RE: STATE INFRASTRUCTURE APPLICATION NO. SSI-9487 INLAND RAIL – NARROMINE TO NARRABRI

Thank you for the opportunity to provide a submission in relation to the Environmental Impact Statement (EIS) for the proposed Narromine to Narrabri (N2N) section of the ARTC Inland Rail Project that has been lodged with the NSW government under State Significant Infrastructure Application No SSI-9487.

Figure B3.1 Existing flooding extents - one per cent AEP event (map 4)

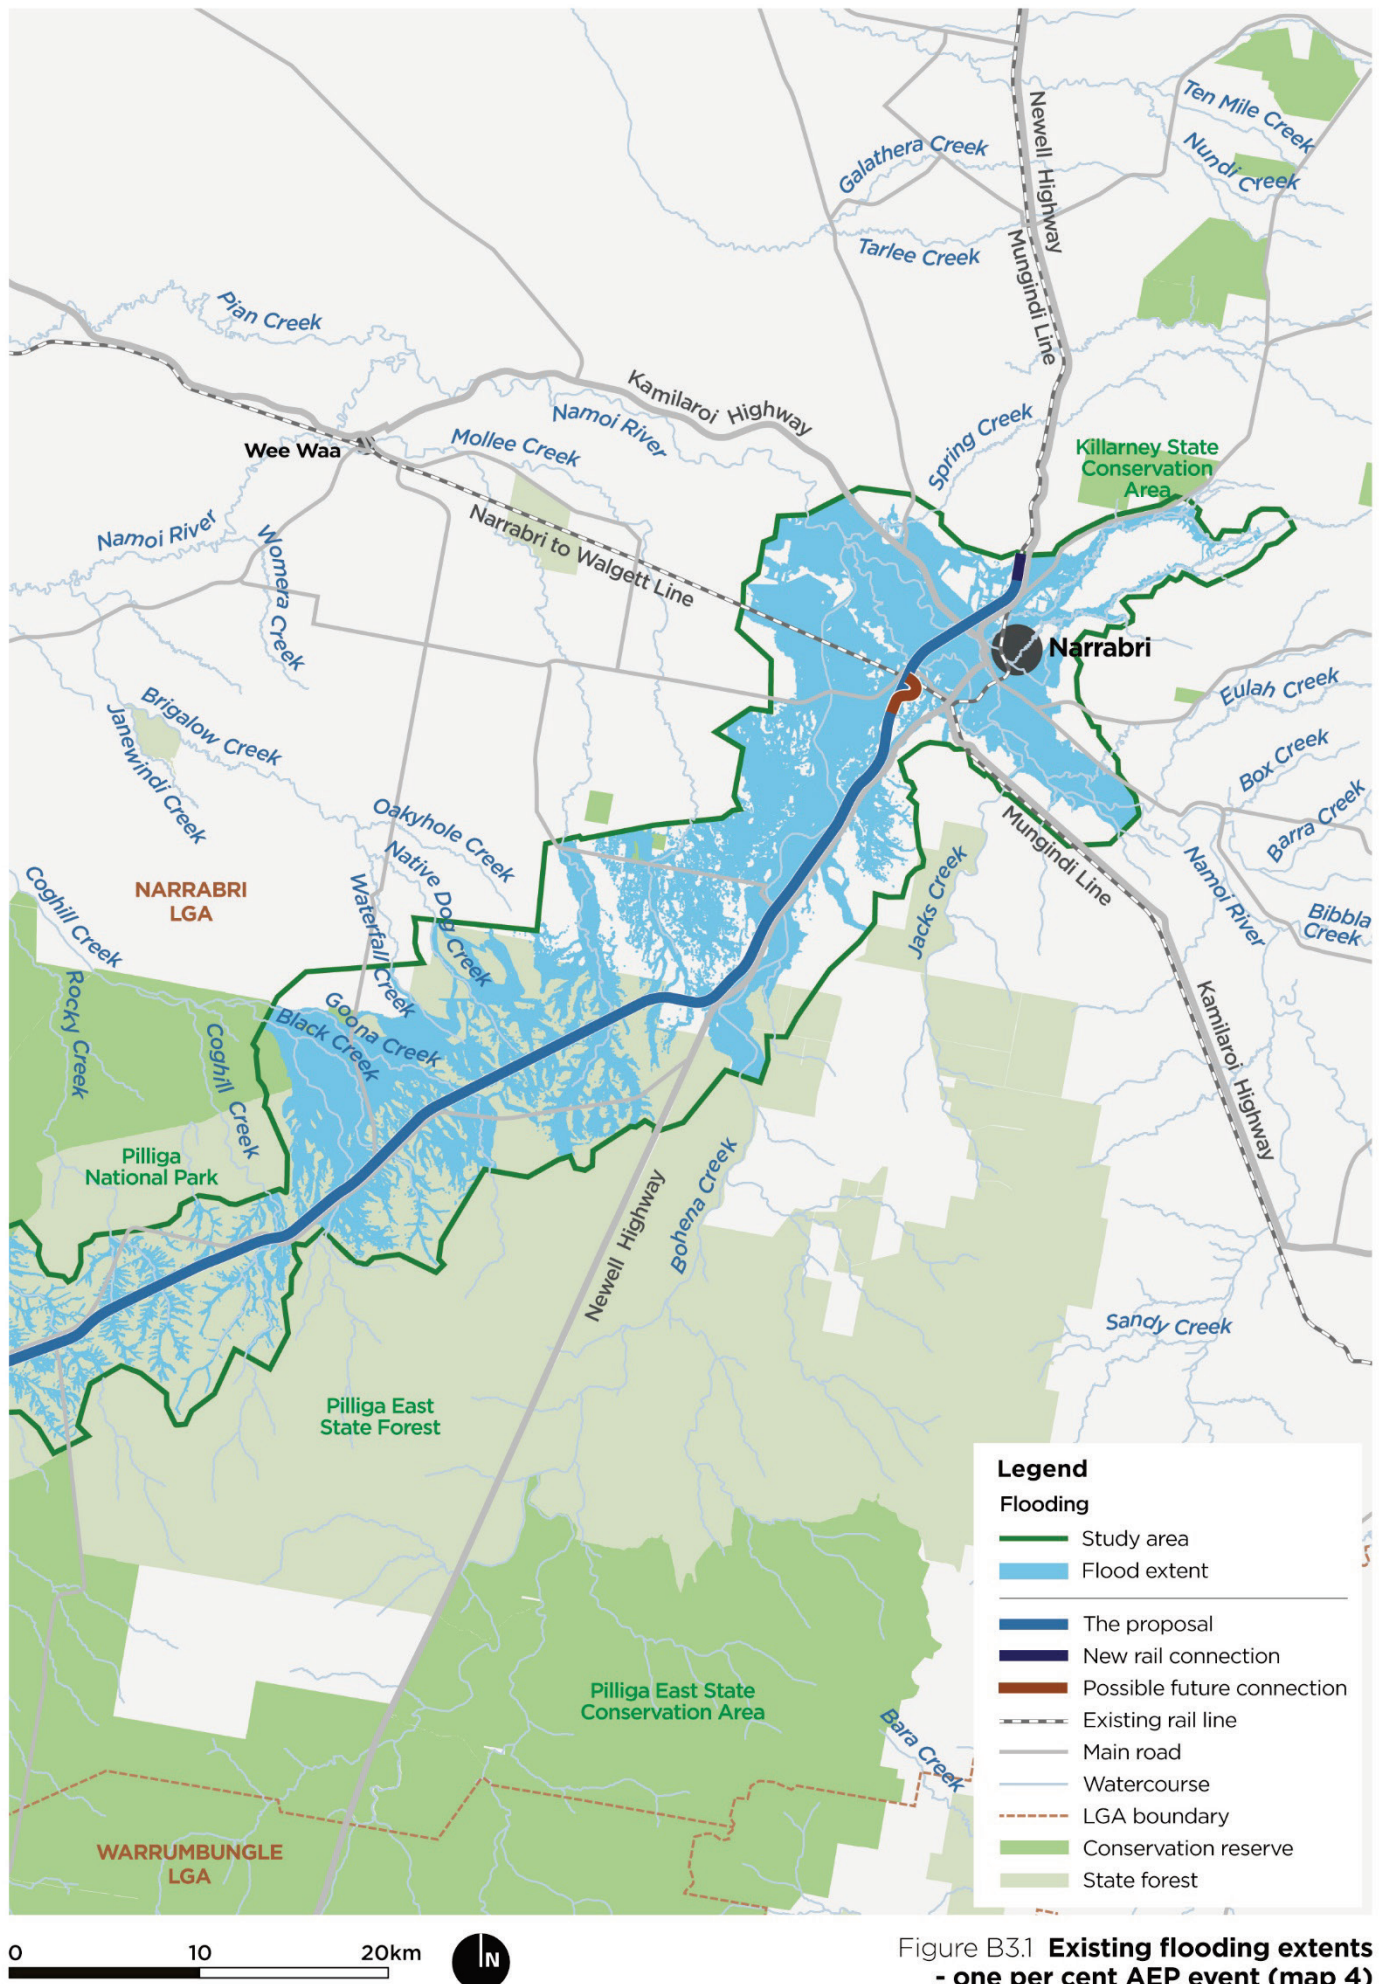
The proposed inland railway crosses several creeks and waterways in the Coonamble Shire, including the Teridgerie Creek. The EIS advises the concentration of overland flows under bridges and through longitudinal drainage and culverts could increase flow velocities and result in scour at outlets and worsening of existing erosional processes within watercourses if scour protection is not provided.

Coonamble Shire Council is concerned about the potential for flooding and drainage impacts on farming properties, dams, roads and natural ecosystems, both upstream and downstream of the proposed railway. The introduction of the new rail infrastructure will change the flooding regime, with the potential to affect surface water flows across floodplains and other areas in relative close proximity to the Warrumbungles (perceived to be flat but with enough of a gradient to result in substantial drainage of storm water towards the west and with the potential to cause significant damage).

Council recommends detailed modelling of the hydrological impacts along the railway corridor as part of the assessment of the SSI Application, to determine site specific downstream impacts of flows from proposed culverts on primary production land, dams, roads, environmentally sensitive land, heritage sites and the like.
